December cases:

2008-155

CATS Development Division

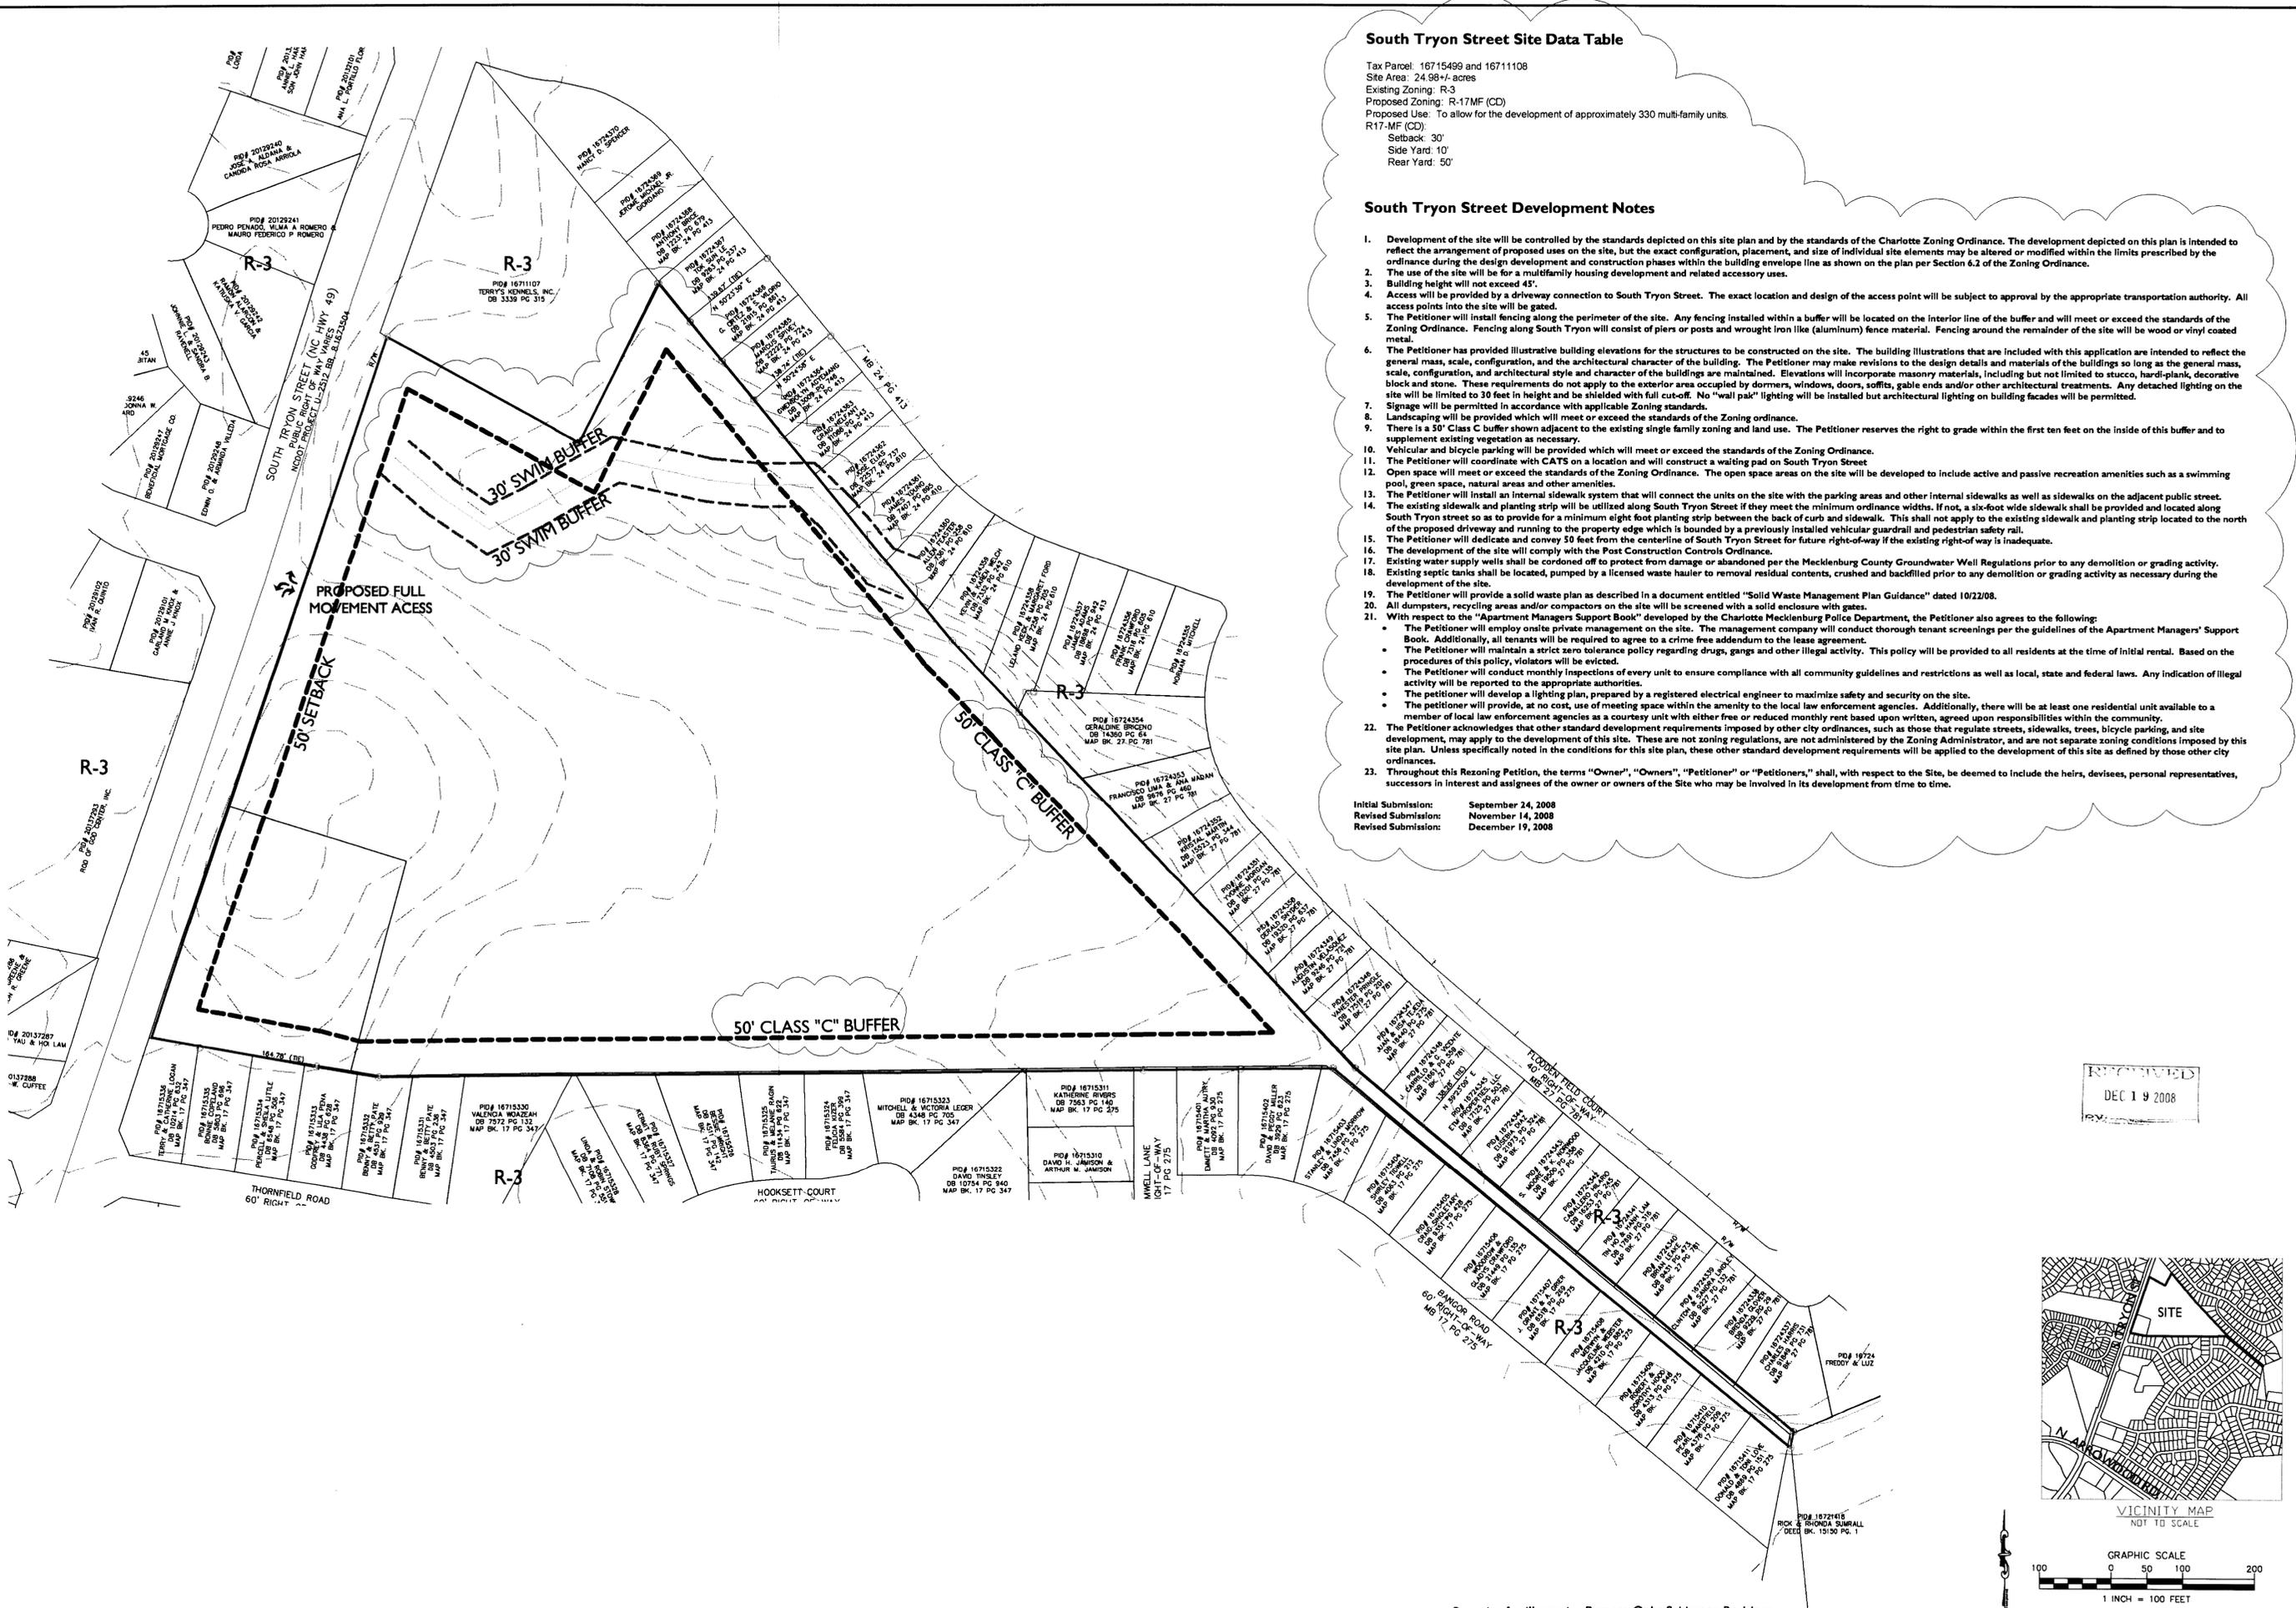
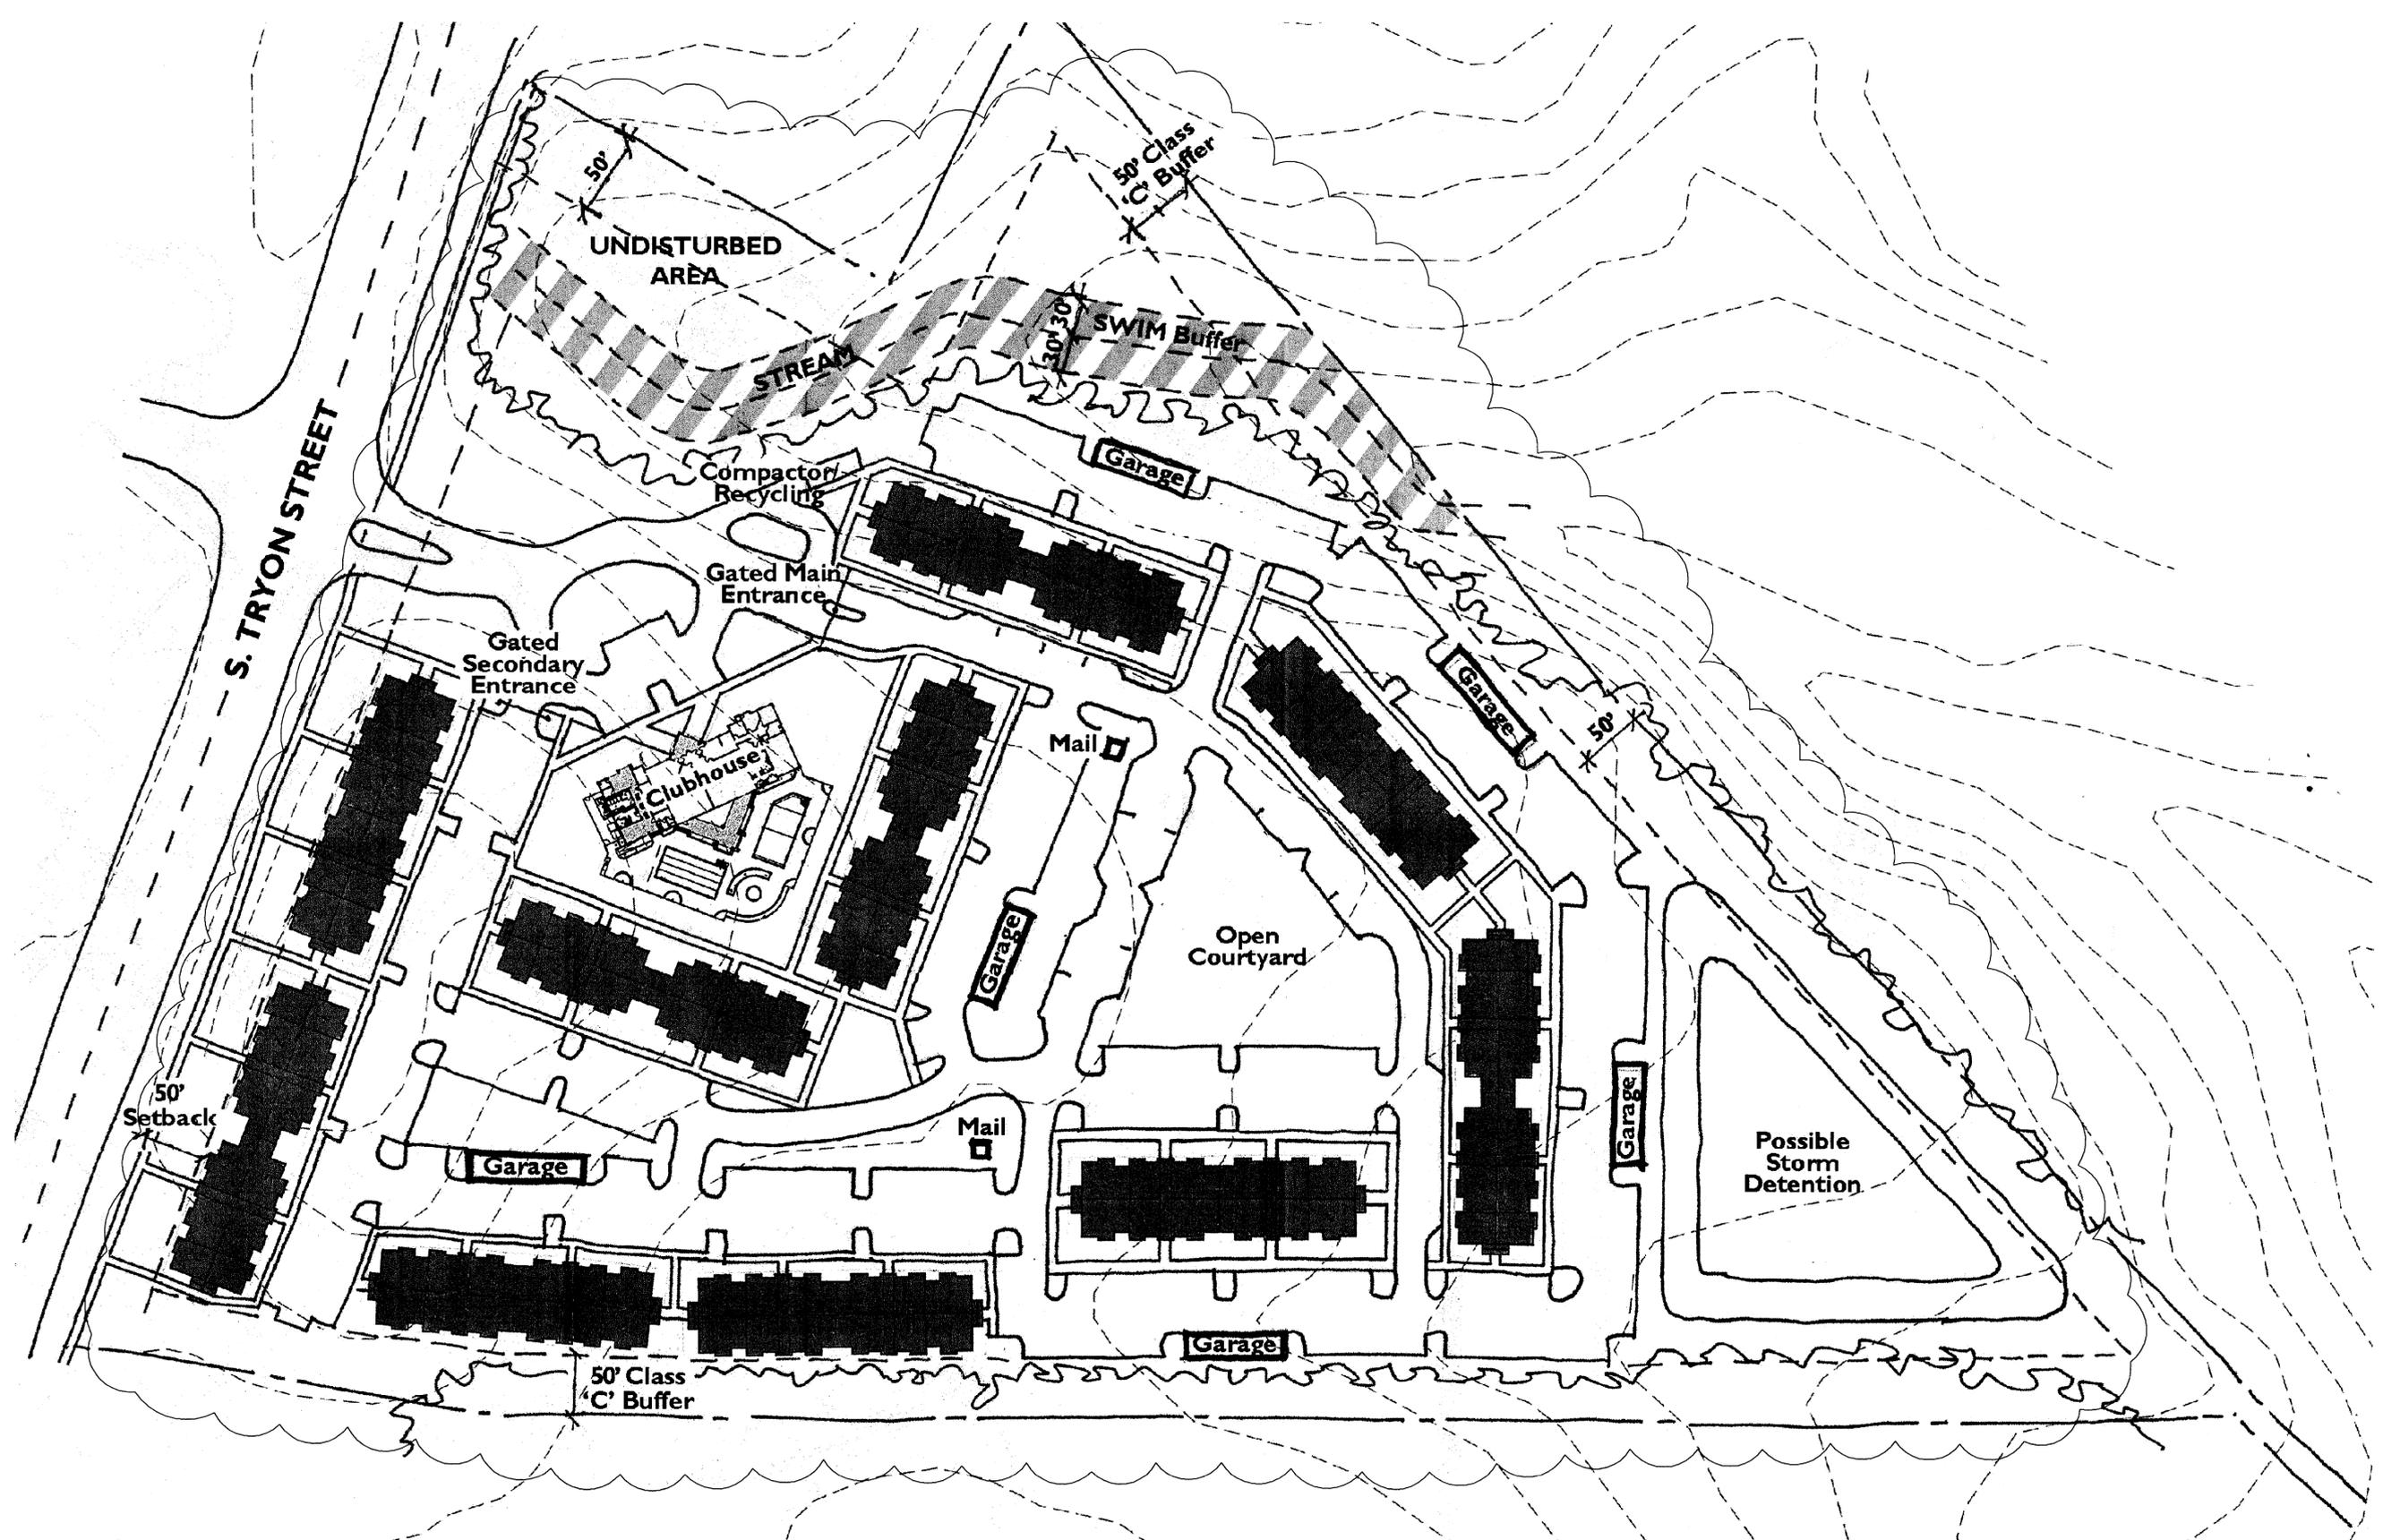
Route #41x. Existing bus stops are currently before and after petitioner's parcel;

CATS is moving stop #46171 (northernmost bus stop) onto petitioner's parcel;

CATS staff would like a shelter pad (60.03A) on S. Tryon Rd. CATS will work with the developer to locate the pad.
